# Rezoning Transportation Analysis

Petition Number: 2019-115

**From:** Felix Obregon, PE  
[fobregon@charlottenc.gov](mailto:fobregon@charlottenc.gov)  
704-432-5729

Revision Log:	Date	Description
	09-29-2019	First Review
	11-15-19	Second Review
	1-9-2020	Third Review
	1-31-2020	Fourth Review

SHEET #:  
**RZ-7.0B2**

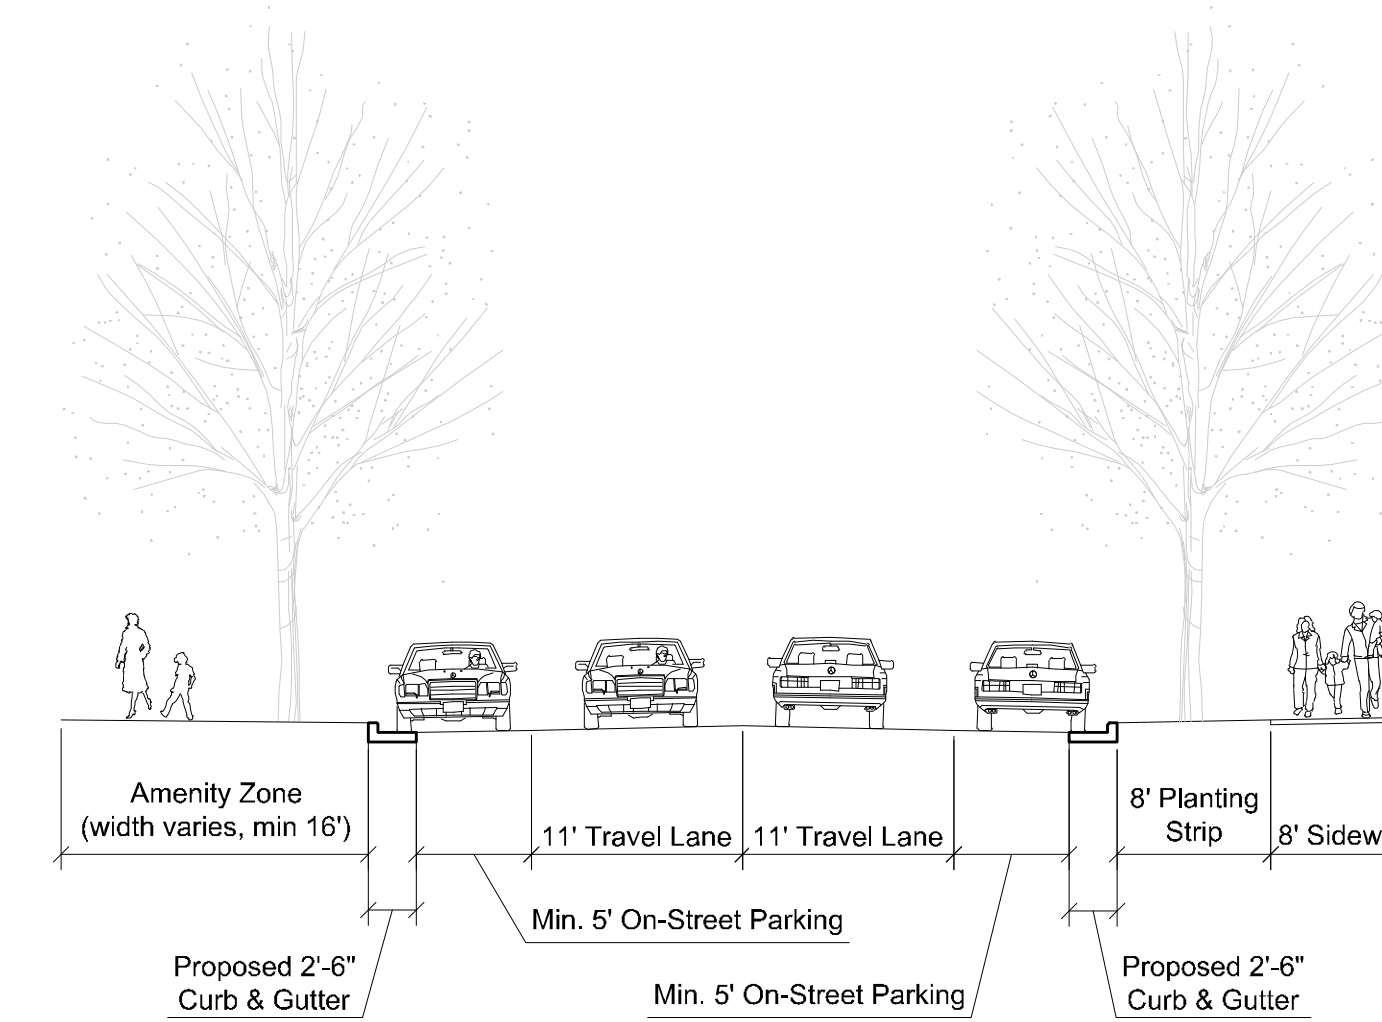
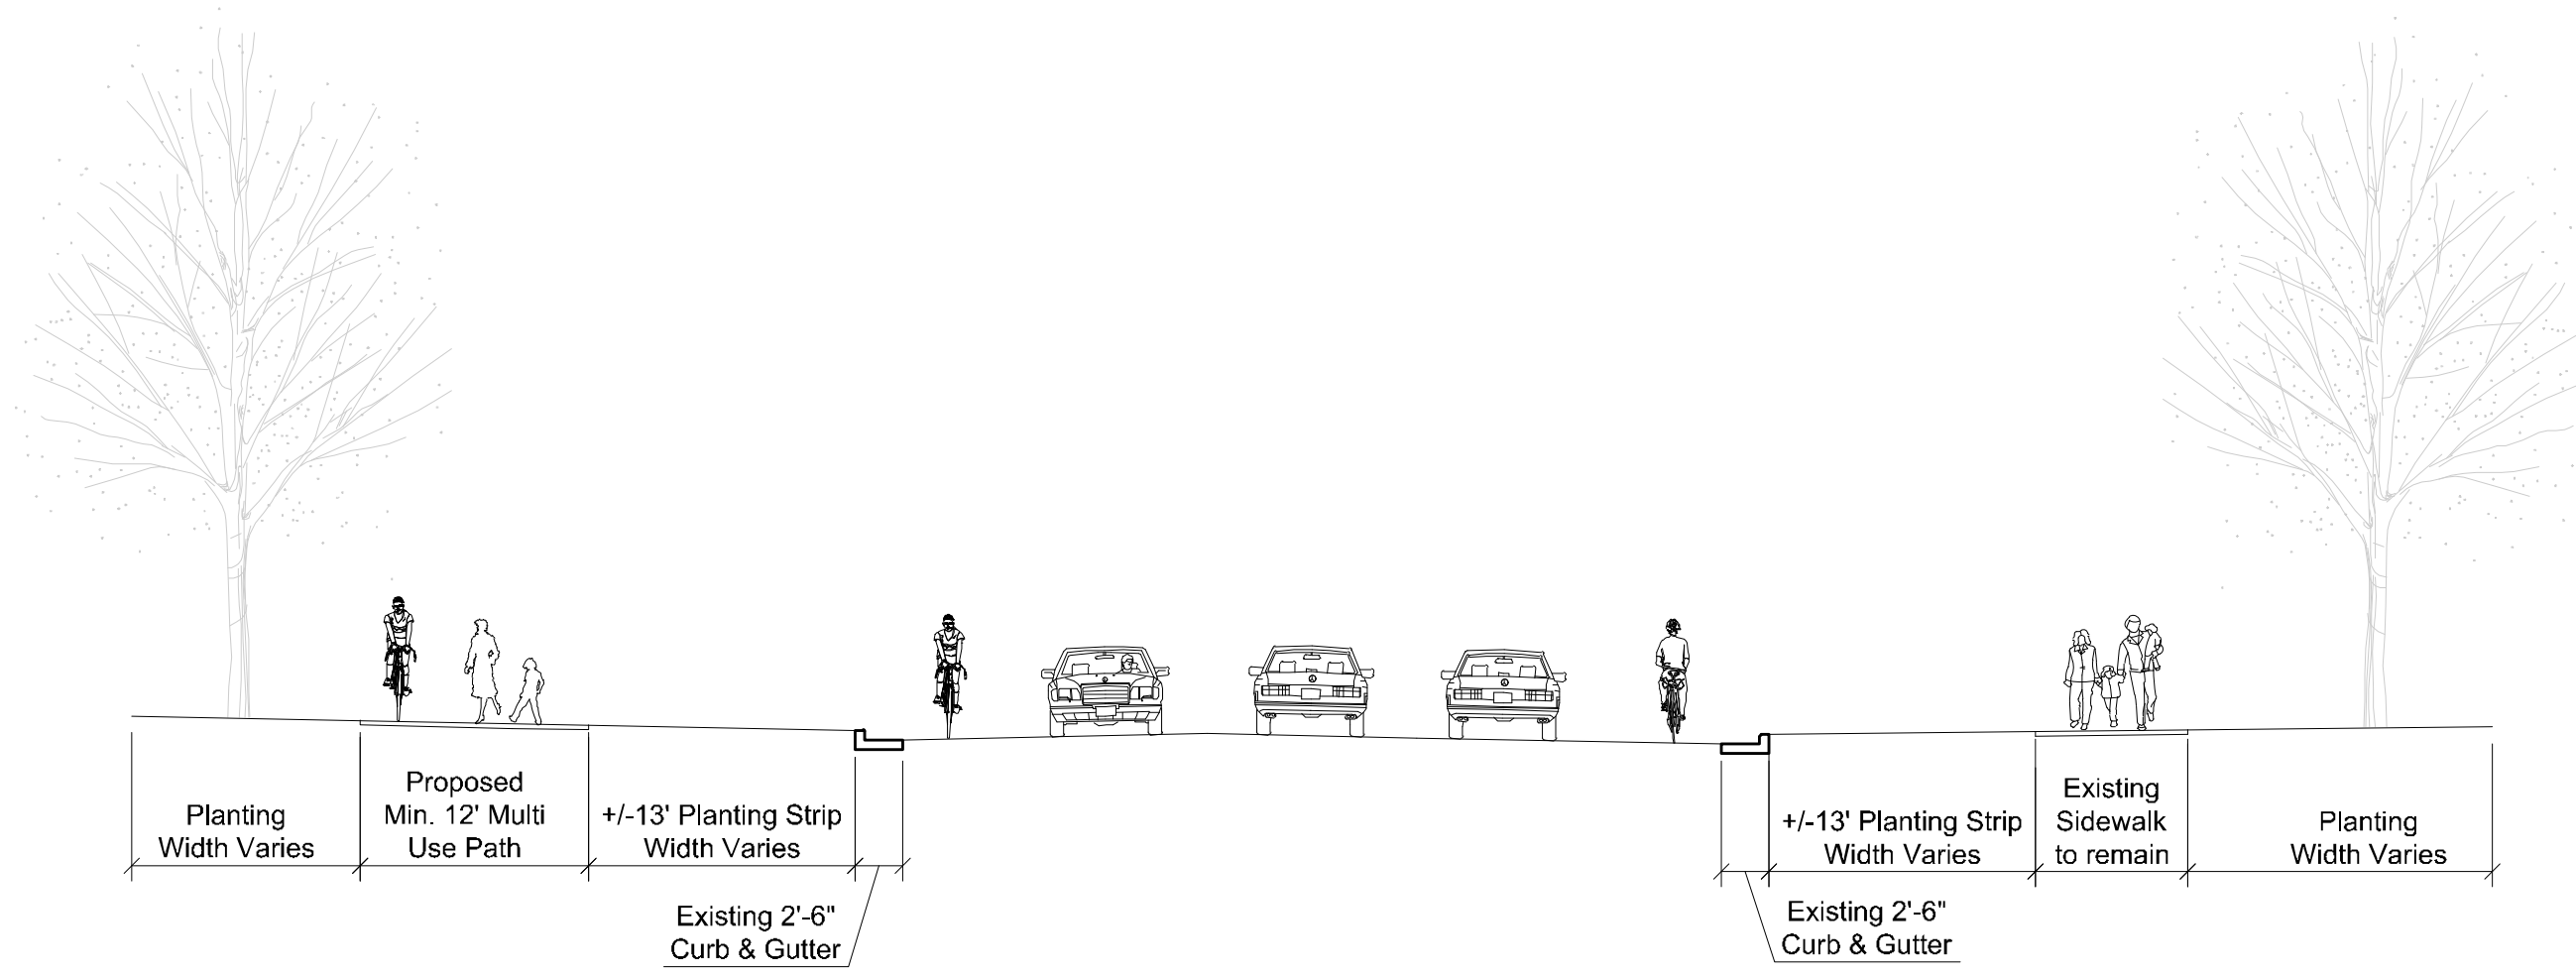
13. Sheet RZ-7.0B shows 2 "Section D" cross-sections and conflict with the street network on Sheet RZ-7.0A. The petitioner should revise the site plan showing the correct matching cross-sections between Sheets RZ-7.0A and RZ-7.0B.

**SECTION F**  
**MULTI USE PATH GREENWAY CONNECTION**  
 (refer to legend on RZ-7.0A)

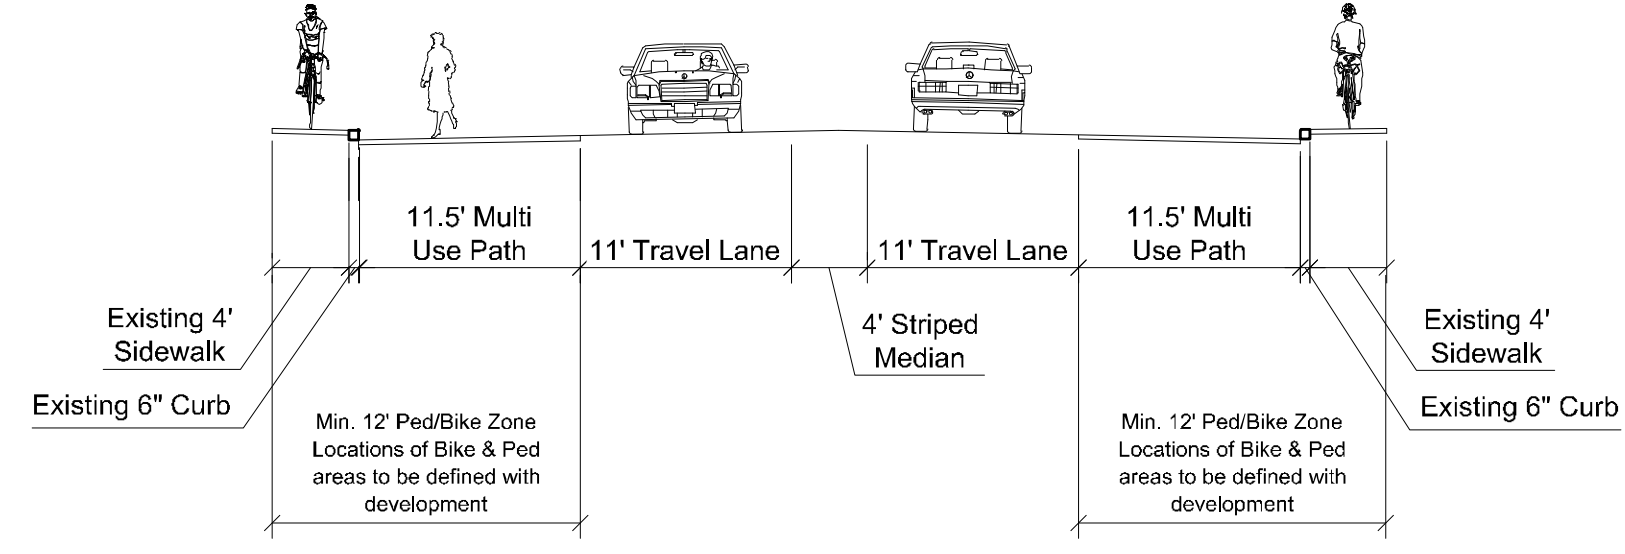
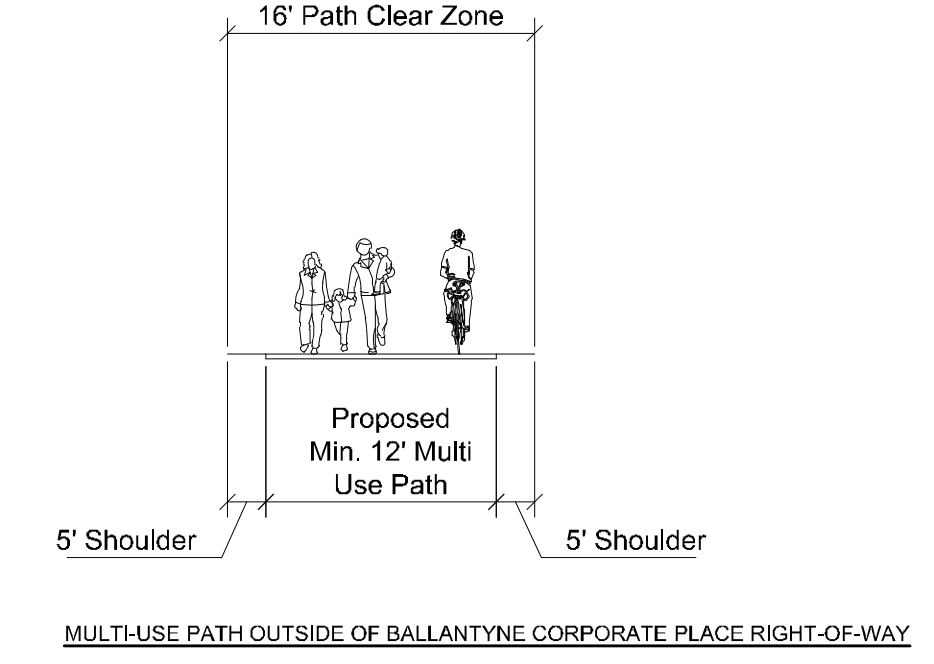
14. The petitioner should revise the site plan and conditional notes to commit to reallocating space on Ballantyne Corporate Place bridge over Johnston Road/521 to be 2 travel lanes, buffered bike lanes, and 8.5' sidewalks.

a. ~~Comment Clarification Based on Revised Site Plan (10/16/19):~~ The Ballantyne Corporate Place bridge cross-section as depicted on RZ-7. OB should be updated to reflect the comments provided below. Furthermore, the total width on the cross-section shown on the rezoning plan does not match the existing width of the bridge. The petitioner should verify the correct width of the bridge is shown accurately on the rezoning plan.
